**Response to Planning application from Hertfordshire County Council (T and CP GDP Order 2015)**

**District ref:** 6/2017/2329/FULL

Land Adjacent 37 Lambs Close

Erection of 3 x 2-bedroom dwellings with associated parking - retrospective

5 Proposed Site Plan - Roof Plan  
1:200

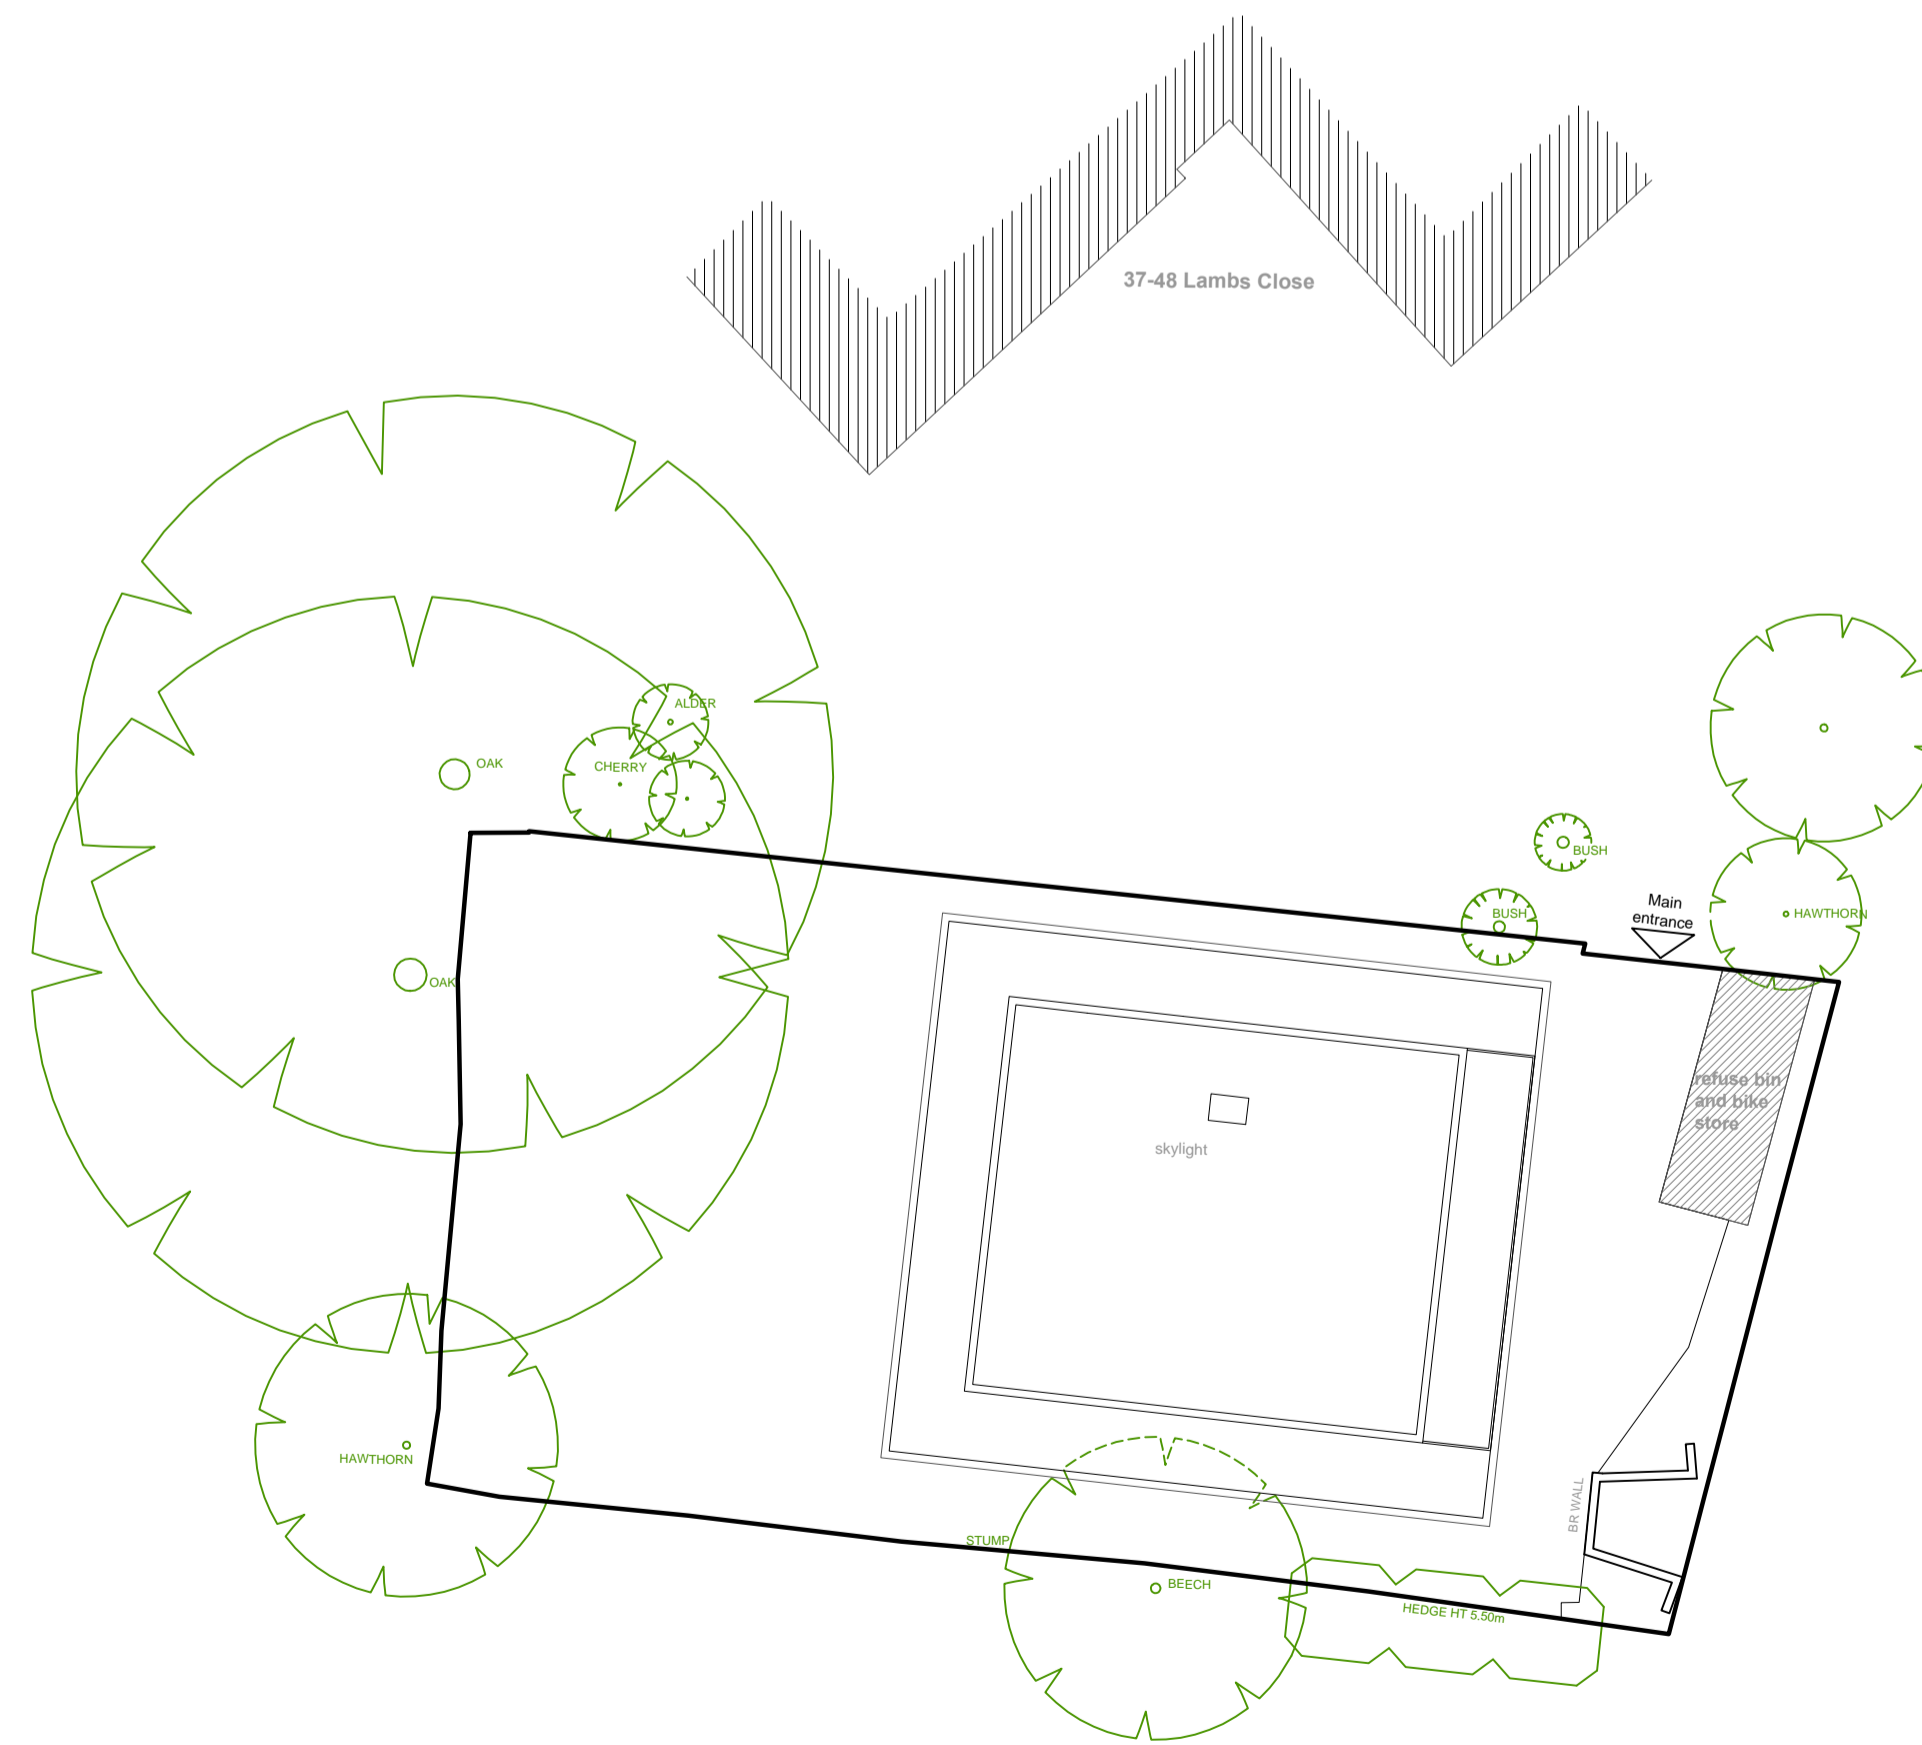
Parking layout provides an appropriate form of layout, all parking spaces are 2.4m x 4.8m in dimension, with a minimum of 6m clear space provided behind each space. Piers upon which the structure over shall be mounted do not appear to prejudice the use of any space. I would observe that the parking layout fails to consider the needs of disabled people, and the LPA may wish to review whether the parking provision should – for the development as a whole (including the flats for which it was originally provided) – include dedicated bays for persons with a disability. Access to the site is limited to existing width (4m) and insufficient to enable two way flow, however the access is set back from the extent of the public highway (Lambs Close, extent of highway maintainable at public expense is clearly delineated on site, but effectively to a point in line between the two blocks of flats known as 25 to 36 and 37 to 45 Lambs Close) and therefore I do not consider that the inability for vehicles to pass clear of other shall have significant implications on highway safety, particularly noting the low traffic speeds and volumes in this area.

The development provides bin stores and as noted in section 4.15, they location would be within safe carry distance, the LPAs waste management team may wish to confirm that sufficient capacity is provided, but I am satisfied that the bin stores are within an appropriate distance from point of collection and will have no material impact on existing servicing arrangements to the site.

The pedestrian access to the units provided ensures pedestrians are guided around the periphery of the car park,

Bin store doors would benefit from auto closing, or be hung such that their impact on vehicle flows be minimized at the access.
